Comments for 9-1-2024 deadline

During the examination the applicant has confirmed (Doc 18.6.2 dated 14-11-2023) :-

Regulation no.5(2)(o)
 Plan No: 2.11 B
 Status - Final

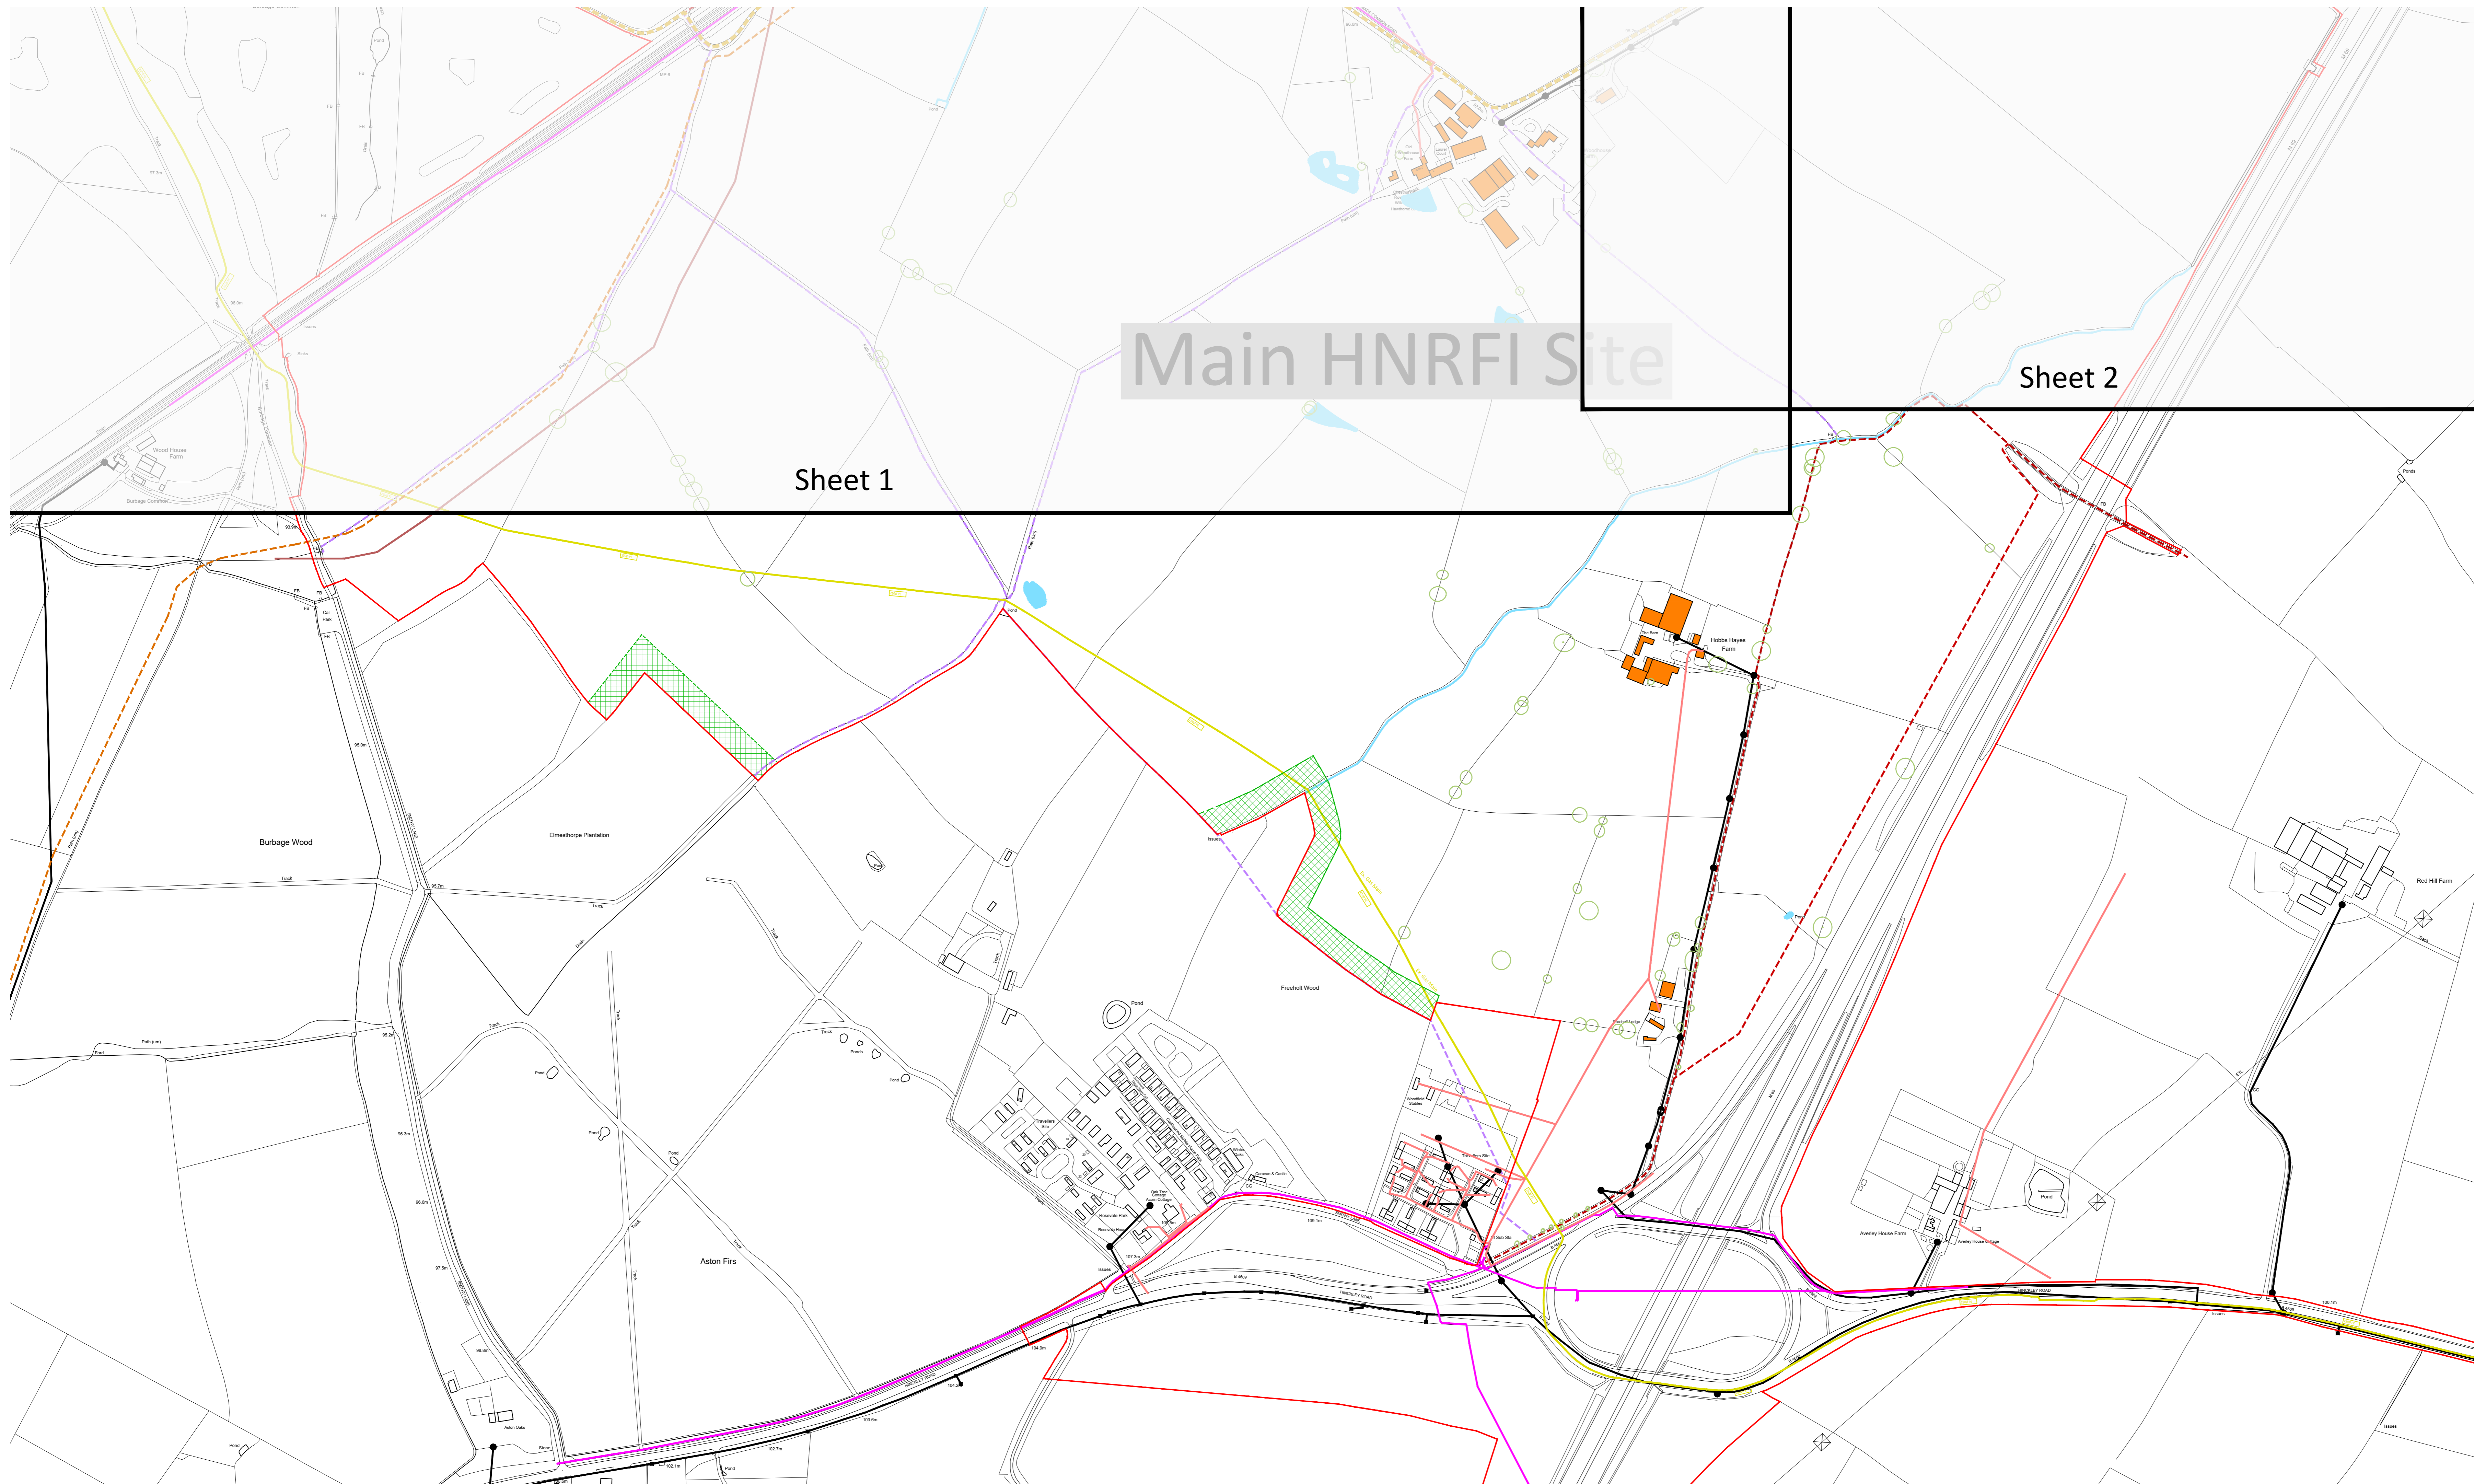
The applicant still has varying responses to the question of the 517mm pipeline (ST) going along and across the mainline railtrack within the proposed site boundaries. It is not a watermain. Away from the actual rail crossing the likely existing ground cover of 1.5 metres includes areas now planned for 6 metre excavation. I have seen no confirmation this pipeline is to be diverted before the earthworks start ?
